OCR & Cabra Drive Residents Committee
104 Old Cabra Road
Dublin 7

Re: Objection to Application

ABP Reg. Ref: KA29N.313691
Applicant: National Transport Authority
For: Blanchardstown Bus Corridor

Programme Title: BUSCONNECTS DUBLIN CORE BUS CORRIDORS INFRASTRUCTURE WORKS			
Drawing Title: BLANCHARDSTOWN TO CITY CENTRE CORE BUS CORRIDOR SCHEME TRAFFIC SIGNS AND ROAD MARKINGS			
Drawing File Name: BCIDC-ARP-TSM_GA-0005_XX_00-DR-CR-0028	Sheet Number: 28 of 40	Status: A	Rev: M01

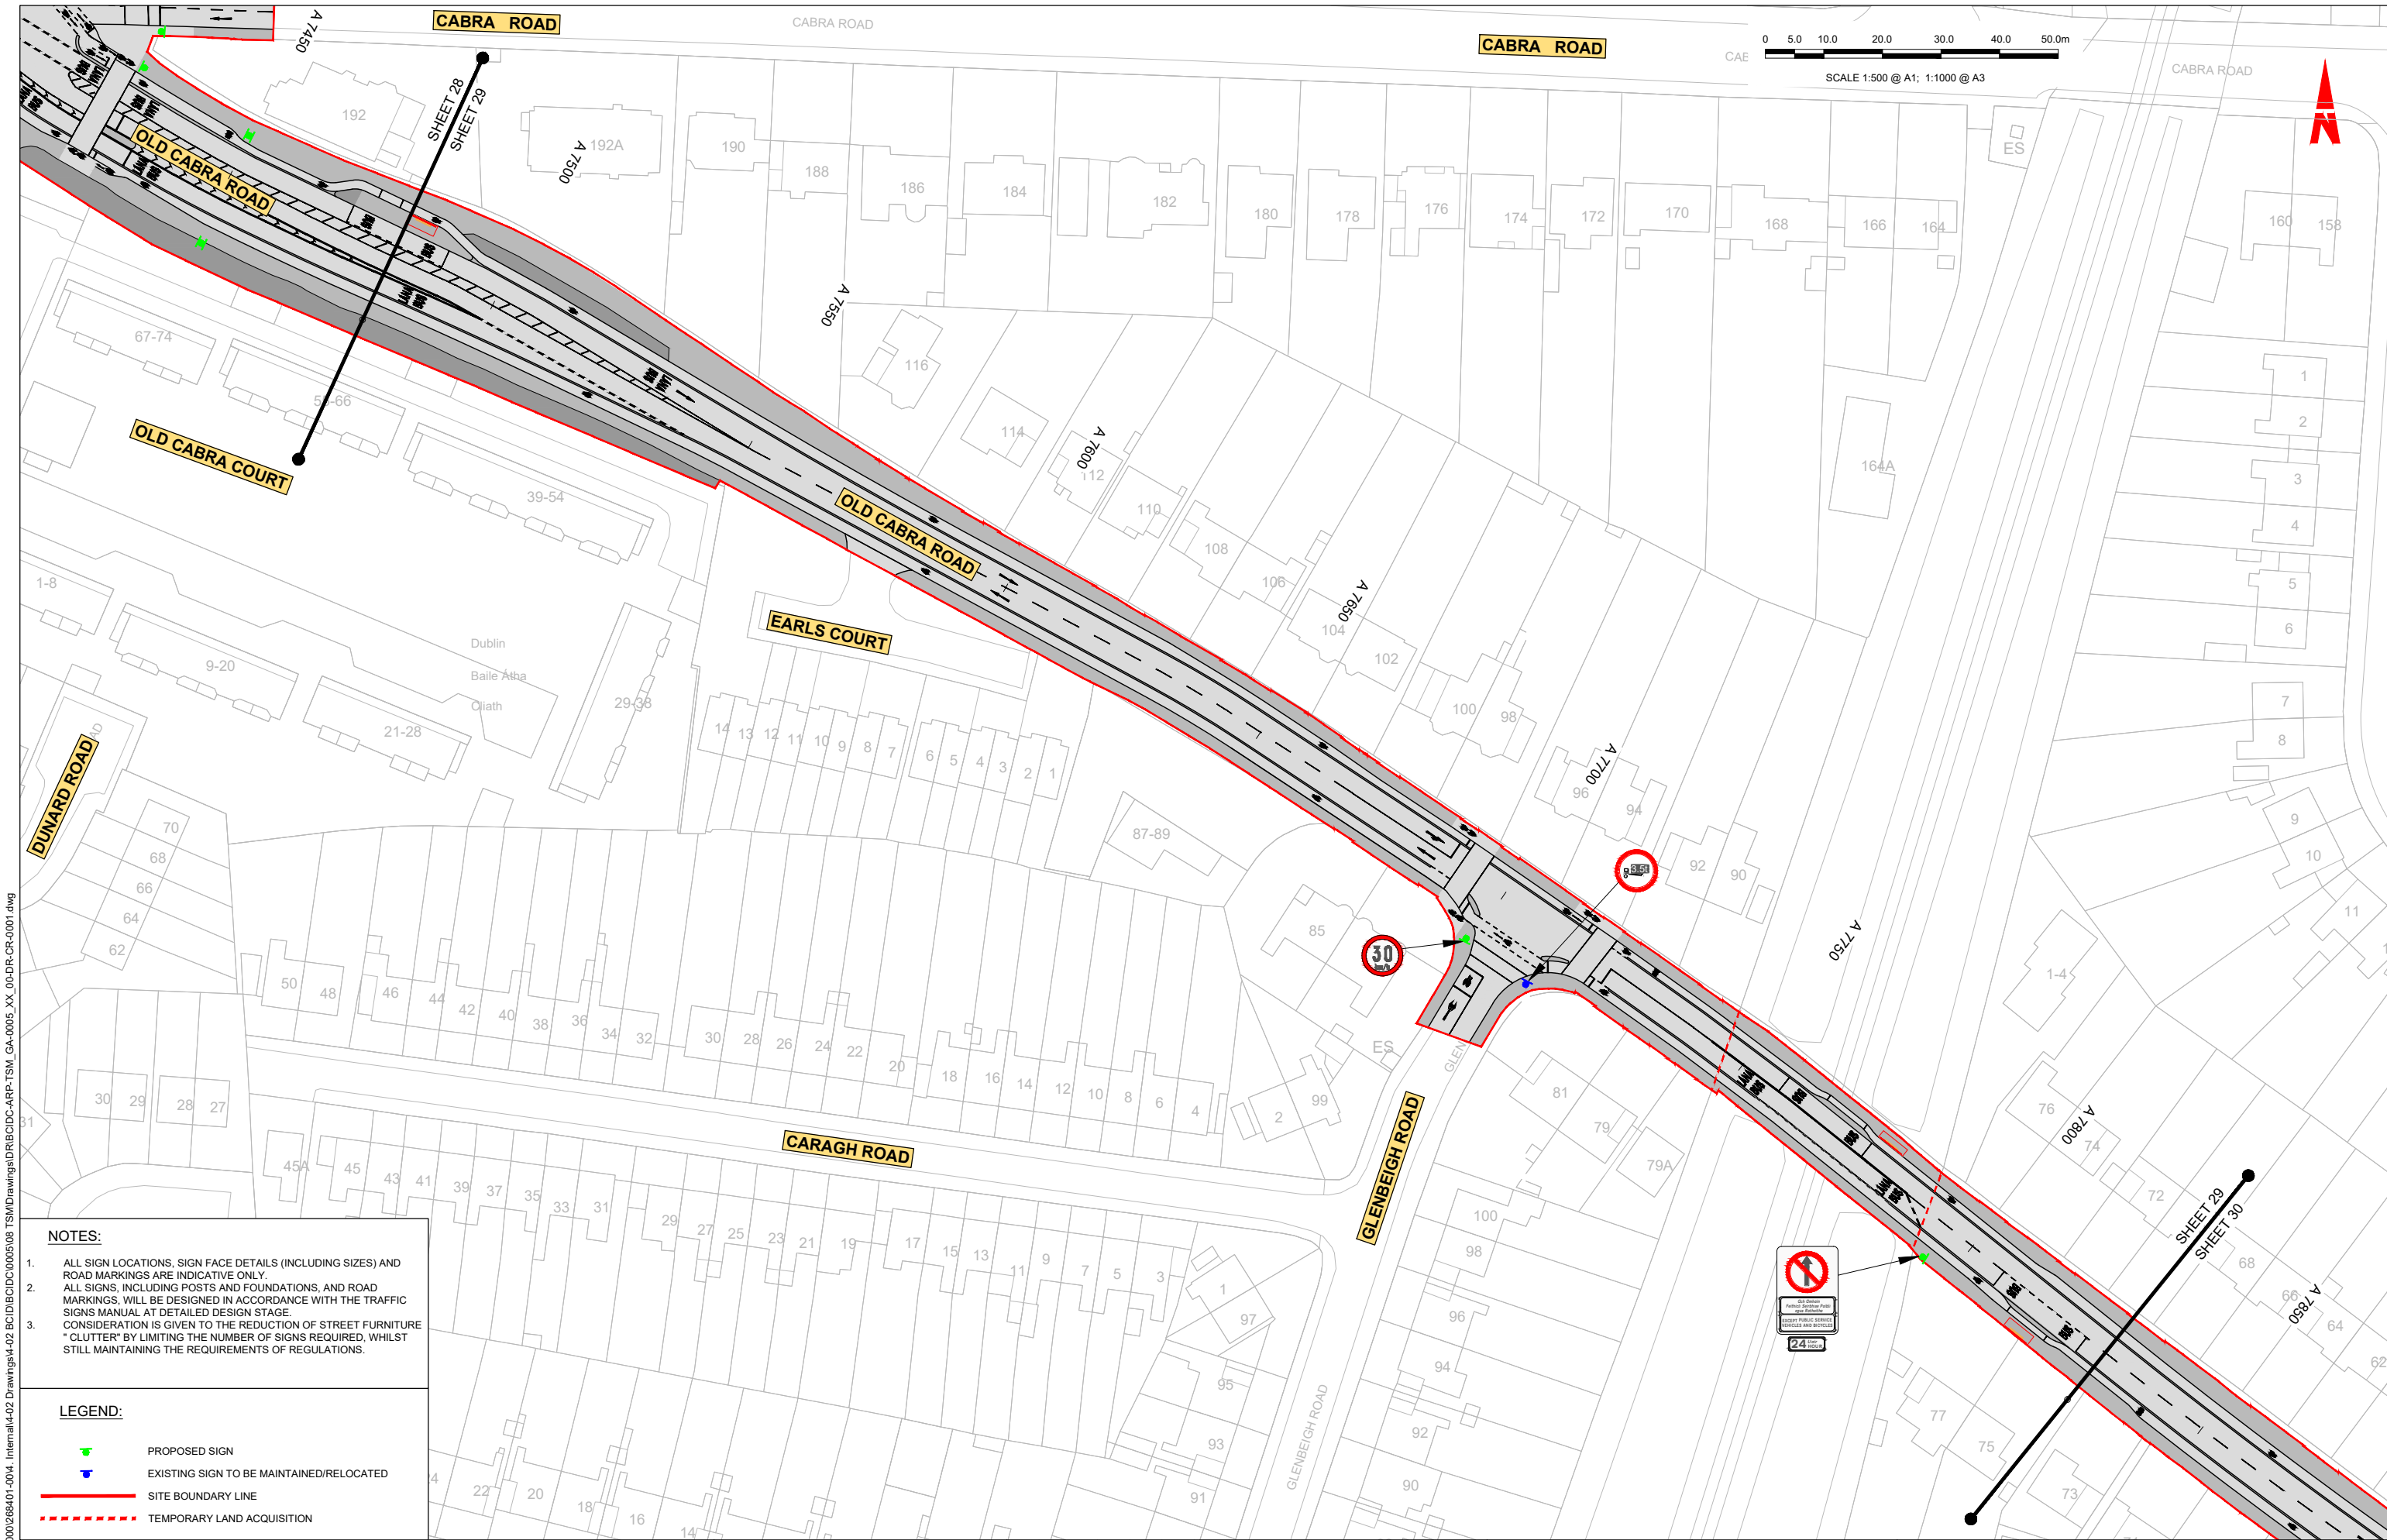
There are excessive restrictions for local residential access for the Old Cabra Road set out in Section 4.5.5.1 of the Environmental Impact Assessment Report (EIAR), including:

- (i) local traffic will be prohibited to travel southbound on the northern portion of the Old Cabra Road (i.e. will not be able to access the Old Cabra Road from the Navan Road junction); and
- (ii) local access travelling northbound will only be allowed as far as the bus gate at the railway bridge.

These onerous restrictions are also reflected in the Traffic Signs and Road Marking Drawing No. BCIDC-ARP-TSM_GA-0005_XX_00-DR-CR-0028 [Sheet 28 of 40] and BCIDC-ARP-TSM_GA-0005_XX_00-DR-CR-0029 [Sheet 29 of 40].

It is recommended that punitive traffic restrictions on residents along the Old Cabra Road and Cabra Drive be removed to allow the local residents to move freely for the length of the Old Cabra Road travelling in both northbound and southbound direction.

We request that an additional Road Sign and/or an amendment to the exceptions as currently proposed on the 'No Straight Ahead' signs be provided at the locations set out in Table 1.1 below. The red text indicates our requested amendment to the existing proposed signs set out by the NTA. (For ease and clarity, please see the Appendix 1 map which sets out the NTA's proposed restrictions on the Old Cabra Road and the suggested alternative signs and exemptions set out Table 1.1).
